## St Joseph's College Physical Education and Sports Precinct Project (PESPP) (SSD 8970)

### RESPONSE TO SUBMISSION

Prepared on behalf of St Joseph's College

13 May 2019 | 16037

LANDSCAPE TO NEW SPORT HALL

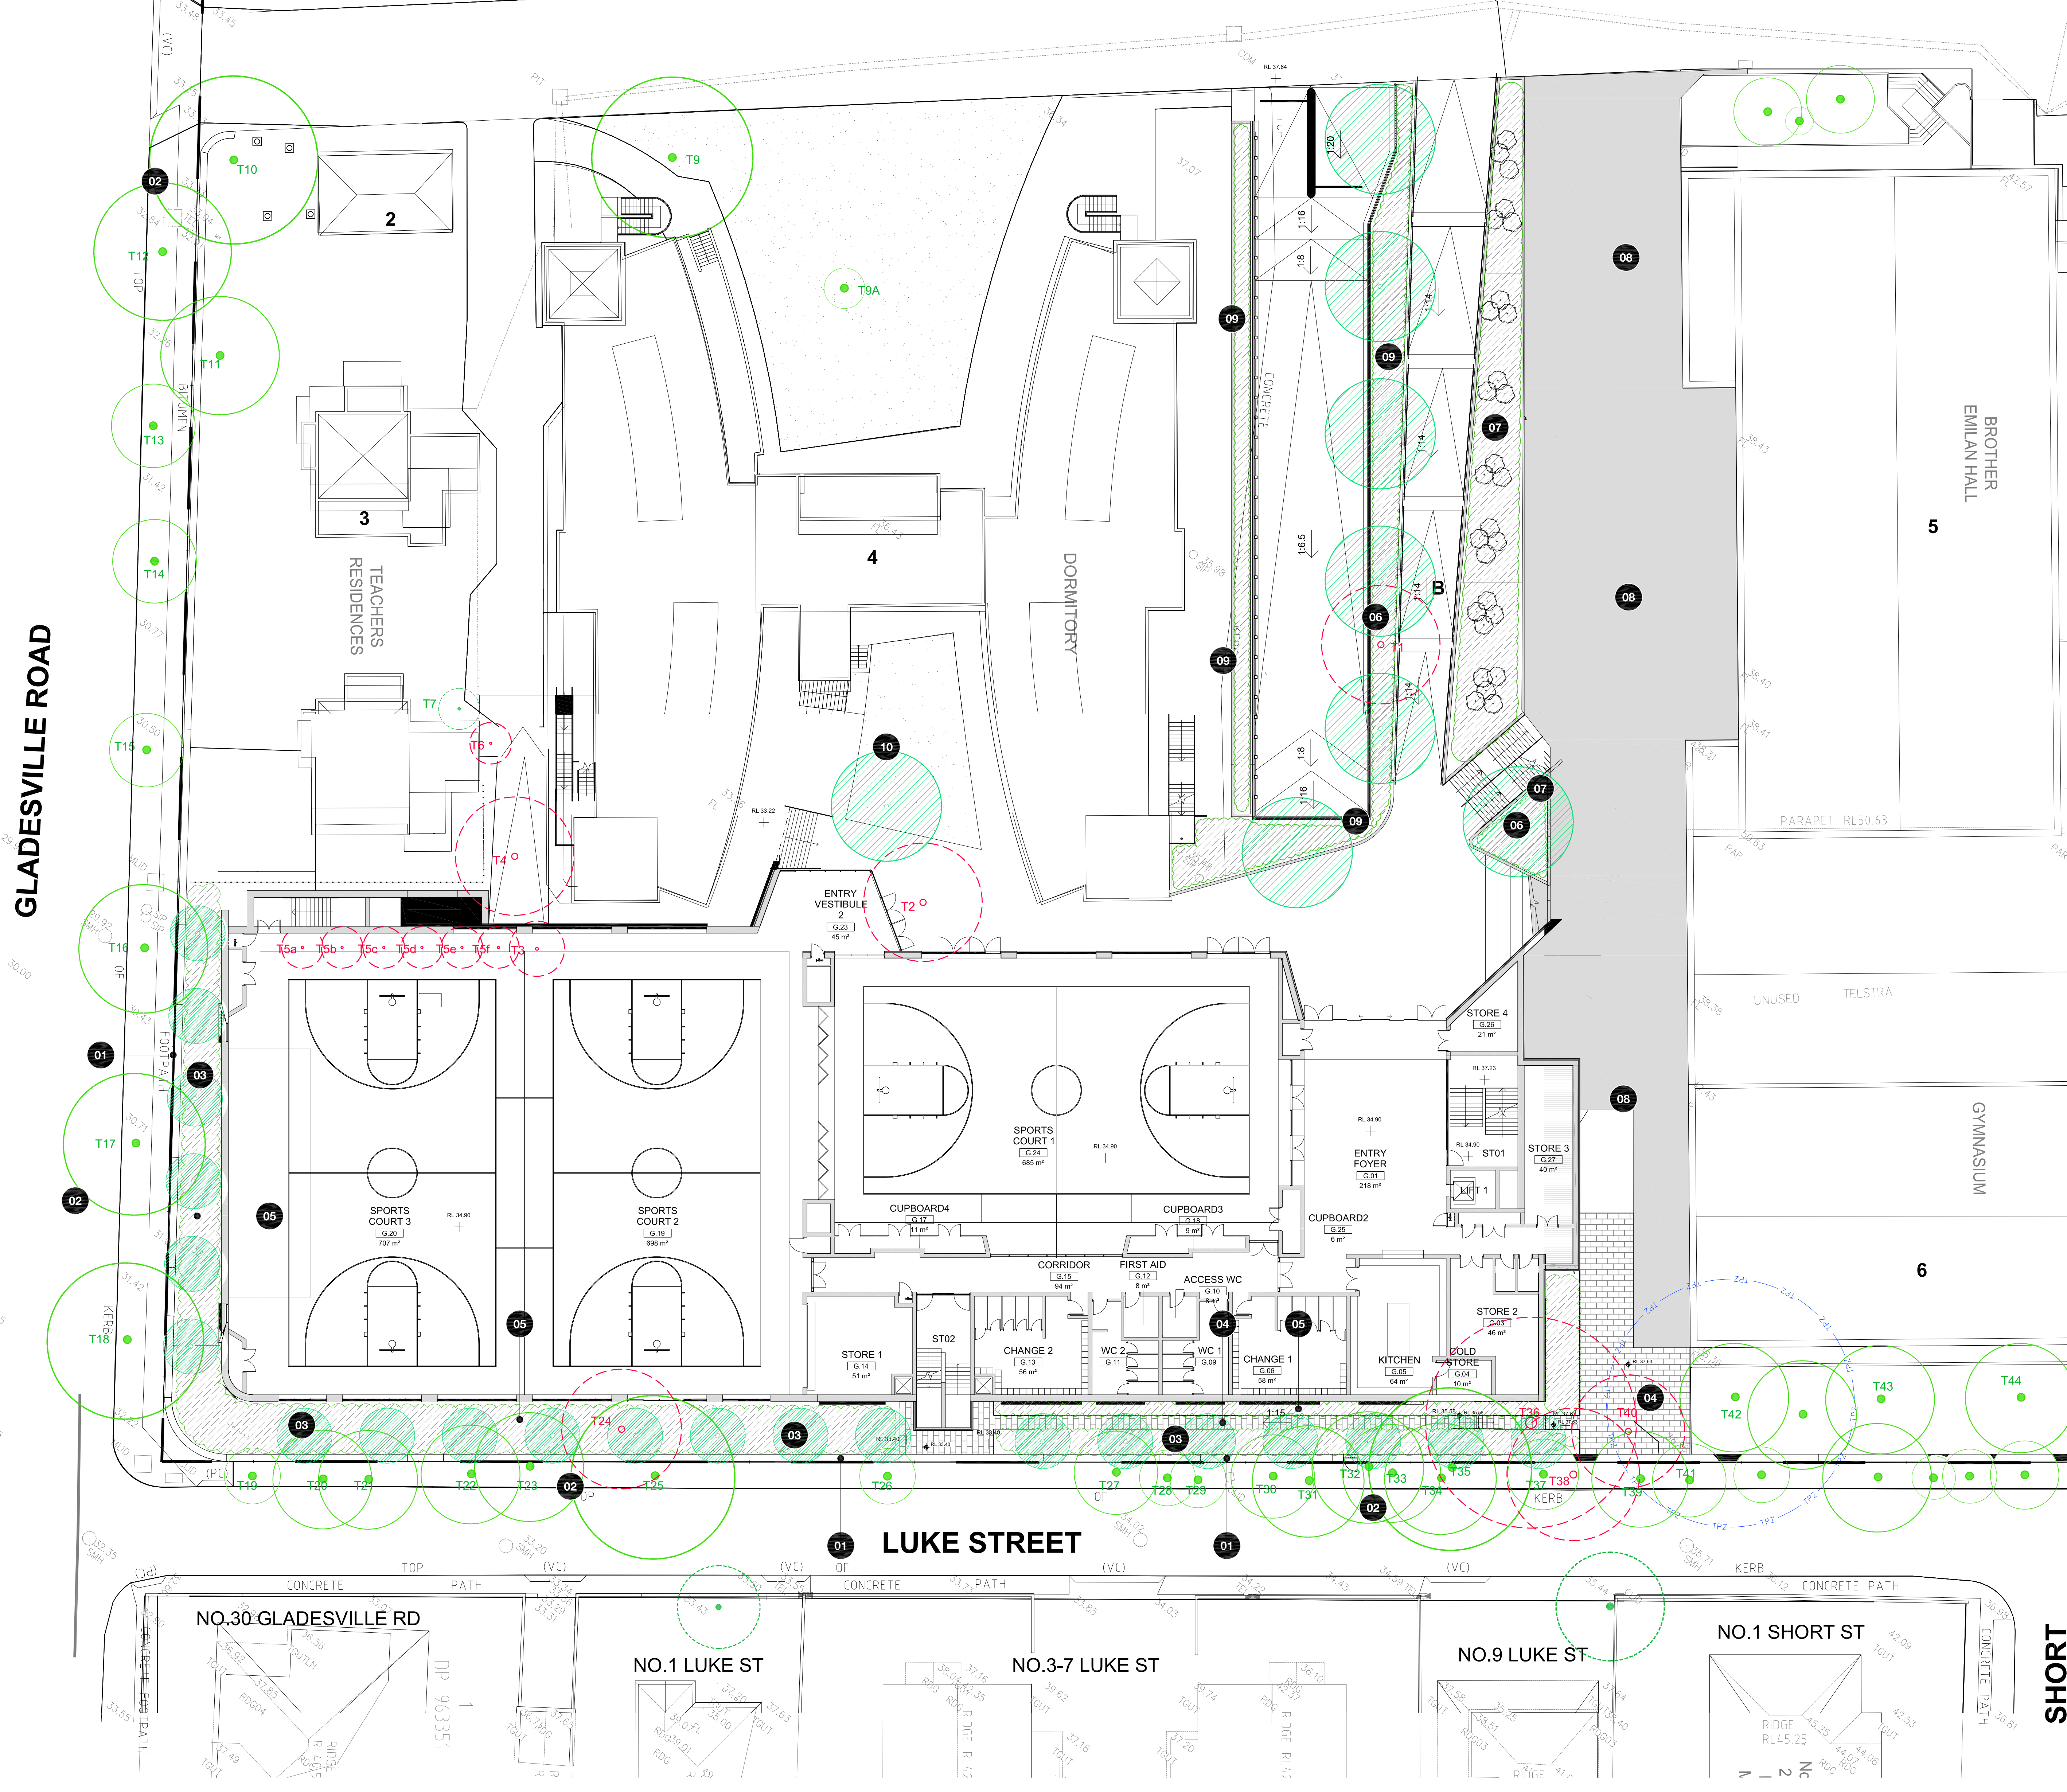
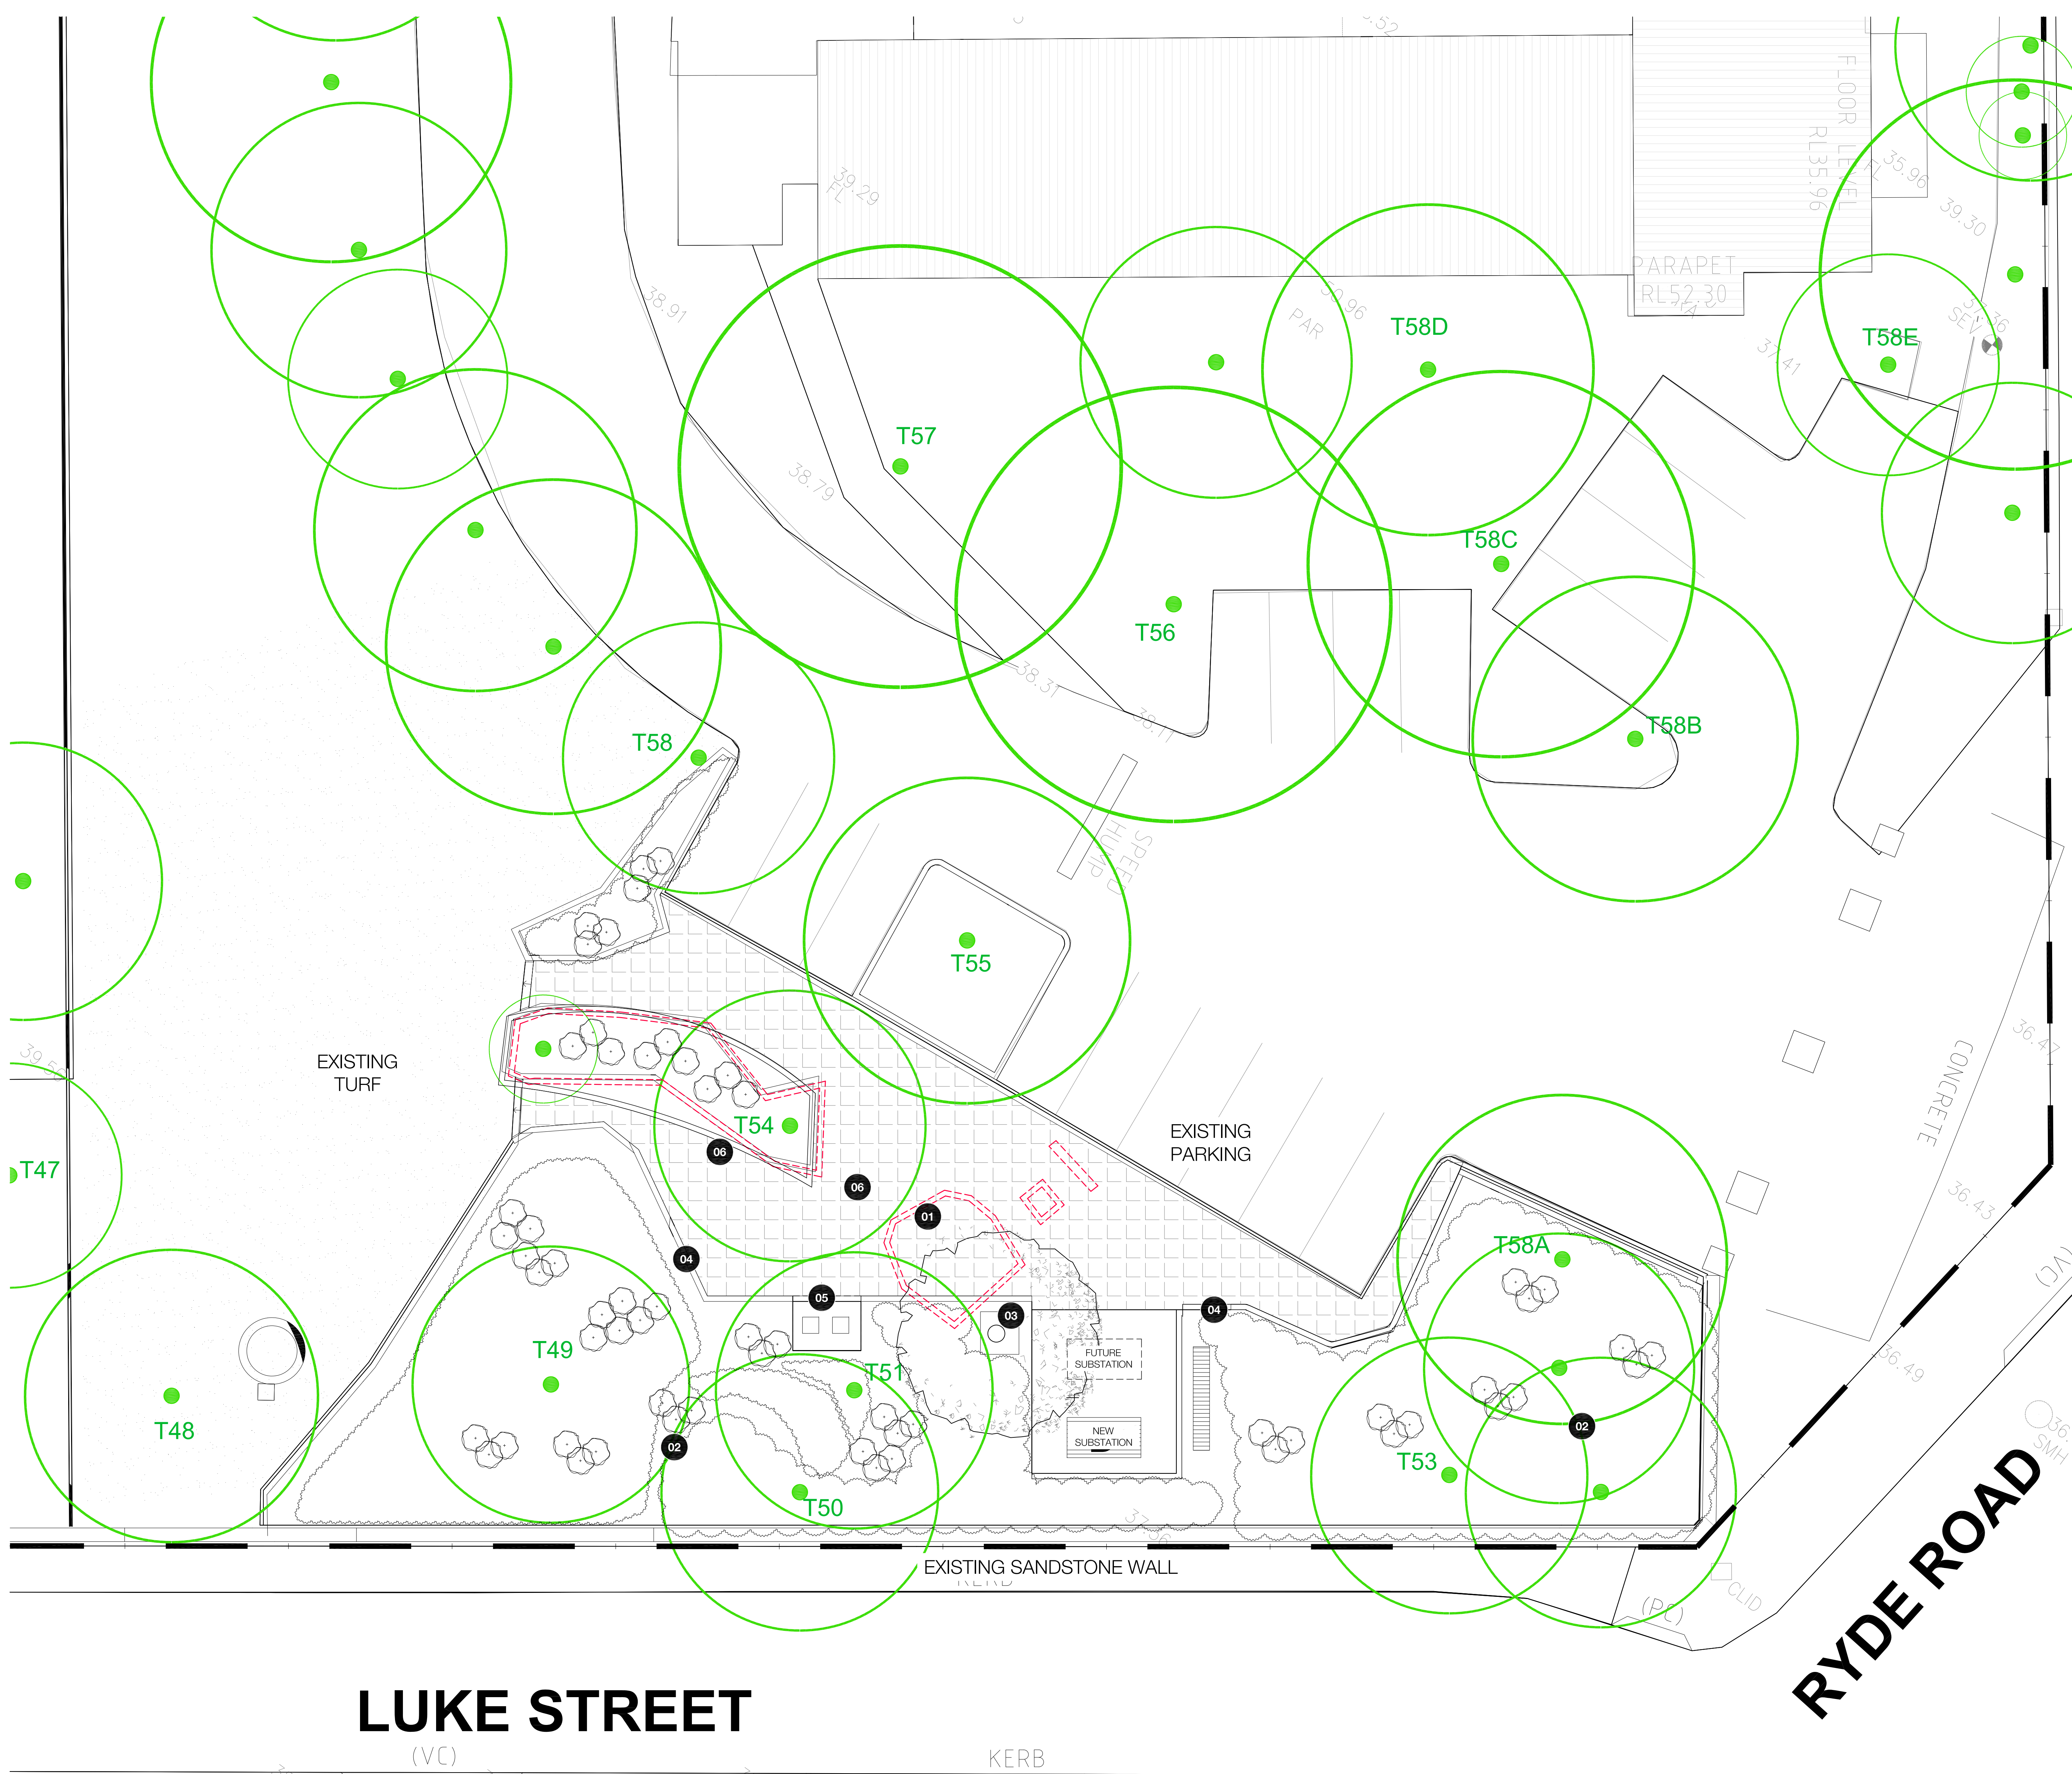
- The submitted plans do not identify the total number of individual trees that are proposed to be removed within the site and outside the boundary of the site. The Department notes that one row of trees has been counted as a single tree, which is not acceptable. Each tree should be individually identified, and the impacts of removal assessed.*

- The Department considers that additional replacement tree planting should be provided within the site, especially along the peripheries (front setback areas), to assist with screening the building and offsetting the loss of tree canopy within the site including six large trees.*

- The Department requires that a comprehensive schedule of the total number of trees that are proposed to replace the loss of tree canopy be submitted. The proposed replacement planting should comprise of native species ranging in height from 14 to 30 metres.*

- Updated landscape plans must be submitted including details of the replacement planting within the site.*

The amended Landscape Strategy (**RtS Appendix F**) and Arboricultural Impact Assessment (**RtS Appendix H**) confirm that the following individual trees are to be removed/replaced:

- Individual trees to be removed:** 16 individual trees are proposed to be removed to facilitate the proposed works (compared with 36 trees in the Original SSDA). The 16 individual trees comprise:
  - 4 High Retention Value trees
  - 6 Medium Retention Value trees
  - 6 Low Retention Value trees
- Trees to be removed outside of the site:** One tree is to be removed outside of the site (Tree 38 on Luke Street) compared with 20 trees which were to be removed in the Original SSDA
- Replacement trees within street setbacks:** A new landscaped buffer is proposed along Luke Street and Gladesville Road including 21 new trees planted on the site between the PESPP and sandstone wall (Lemon Scented Honey Myrtle (*Backhousia citriodora*), 14-30m high at maturity).
